REFUSAL OF PLANNING PERMISSION

APPLICATION NO. 2009/1234

Proposal Raising of roof height, installation of front and rear dormer windows and erection of single storey side and rear extensions to dwelling (Resubmission)

At 8 Ambleside Grove, Ardsley, Barnsley, S71 5DP,

FRONT ELEVATION

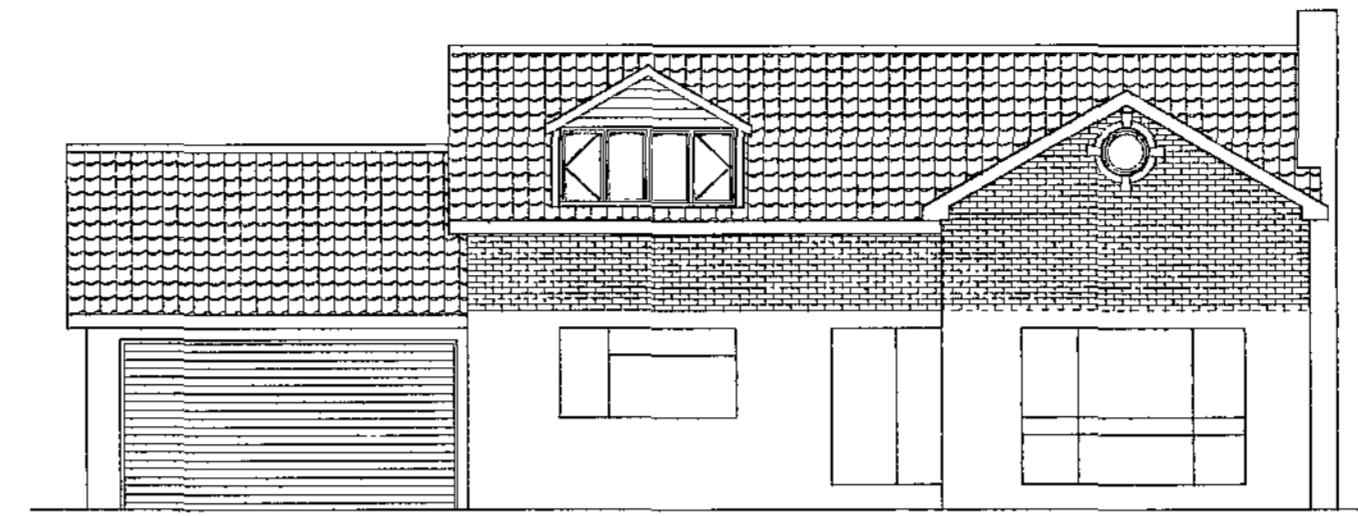
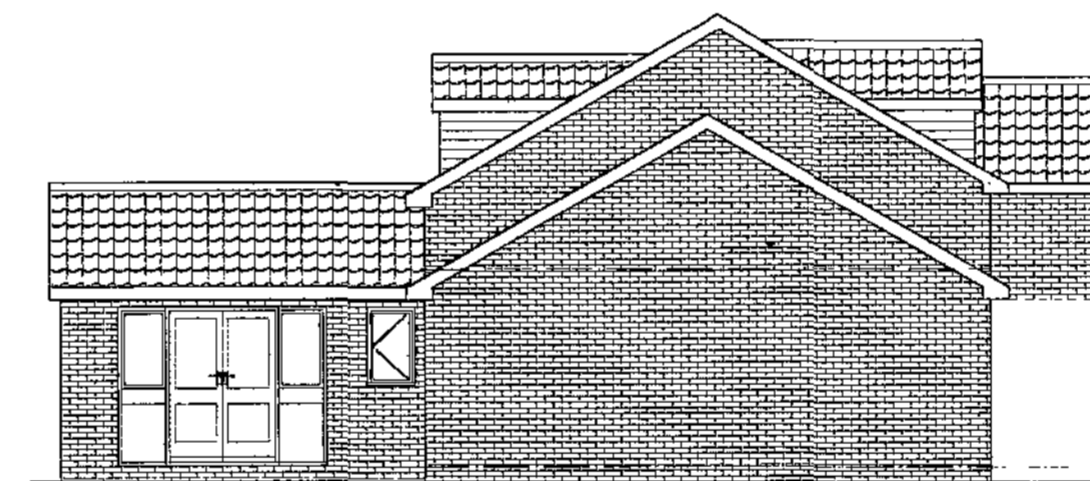
- 1 In the opinion of the Local Planning Authority the proposed front dormer and raised roof height would be contrary to Policies H8E & BE6 in the Unitary Development Plan and the Council's Supplementary Planning Guidance Notes 4 & 5 in that the proposed design would be architecturally inconsistent with the existing property and would fail to maintain the character of the streetscene to the detriment of visual amenity.
